Your Ref: OWPC23743
Our Ref: K/19/19/HH 25-06-2019
Please ask for:
Zac Denton

Two storey rear extension with a small canopy projecting the footprint to the front.
Demolition of existing living room and additional first floor for habitable use with
alterations to fenestration.

Little Tangley Middle Way Kingston Gorse East Preston

Thank you for your internet representation made on 23rd July 2019 which has been recorded
as '**an objection**' with the comments as follows:

Proposed Section AA

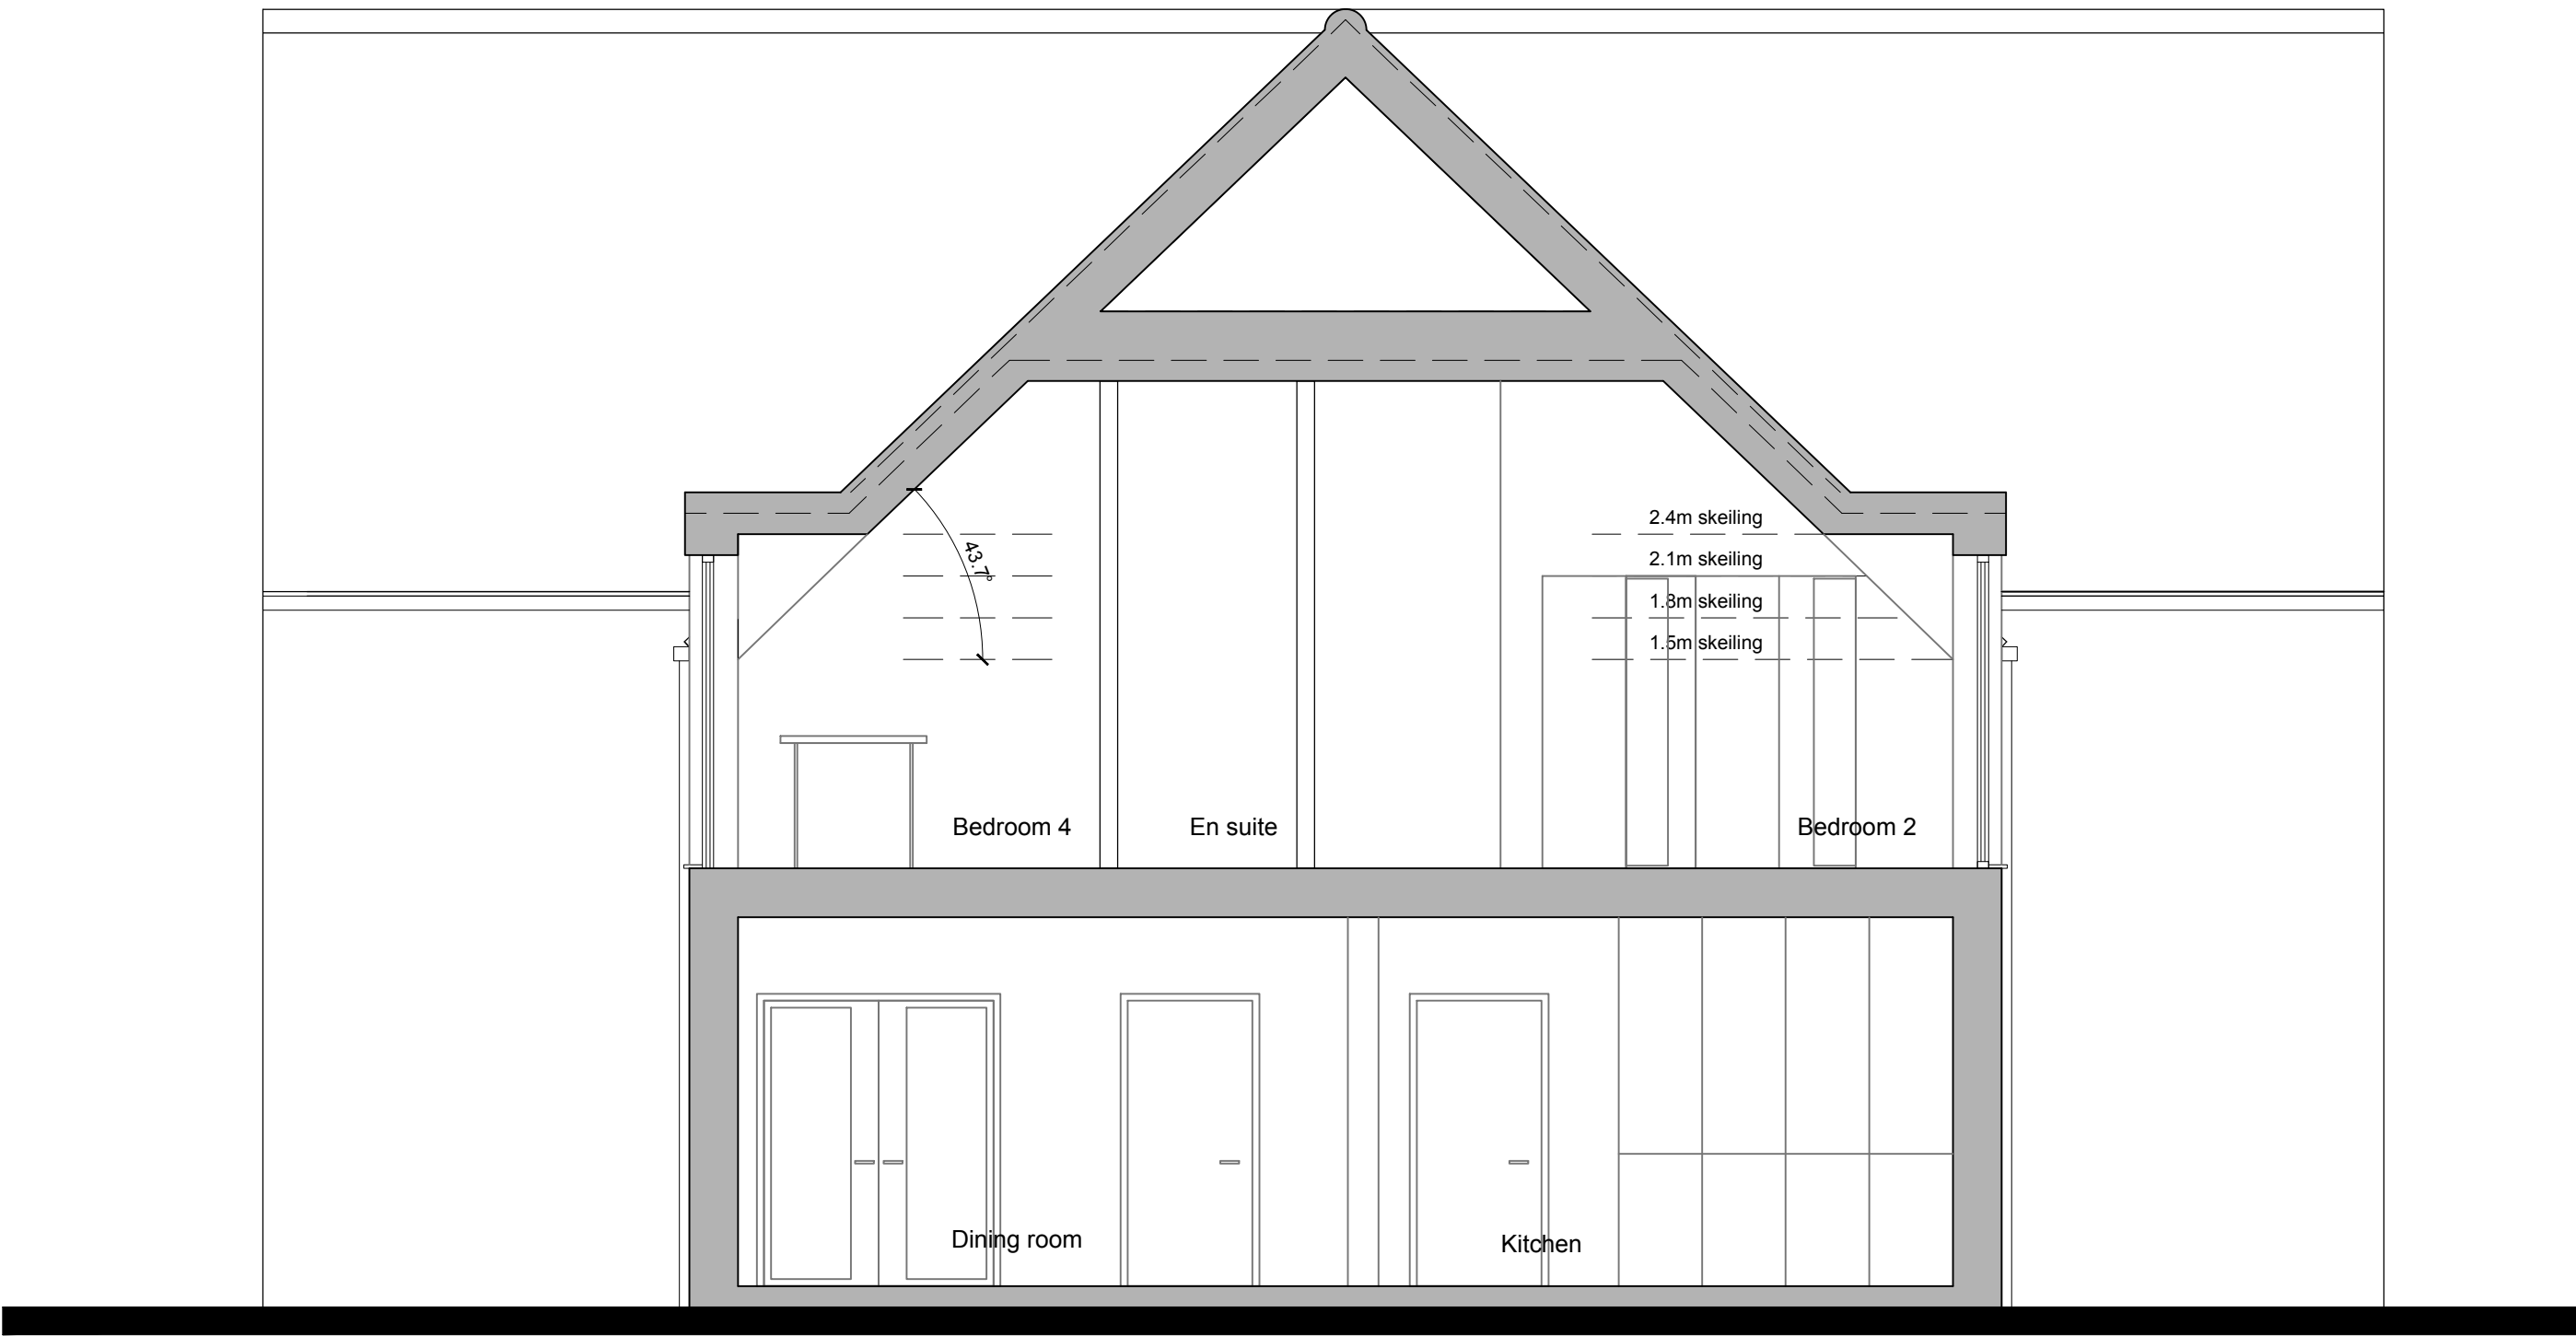
*The existing chalet bungalow is essentially a single storey dwelling with one bedroom in
the roof. The proposed development, which is somewhat coyly termed an "extension" by
the applicant but is effectively the construction of a new house, seeks to increase the
overall mass of the property by more than 200% with a substantial increase in
accommodation to five bedrooms and a very significant raising of the ridge height. We
believe this constitutes overdevelopment.*
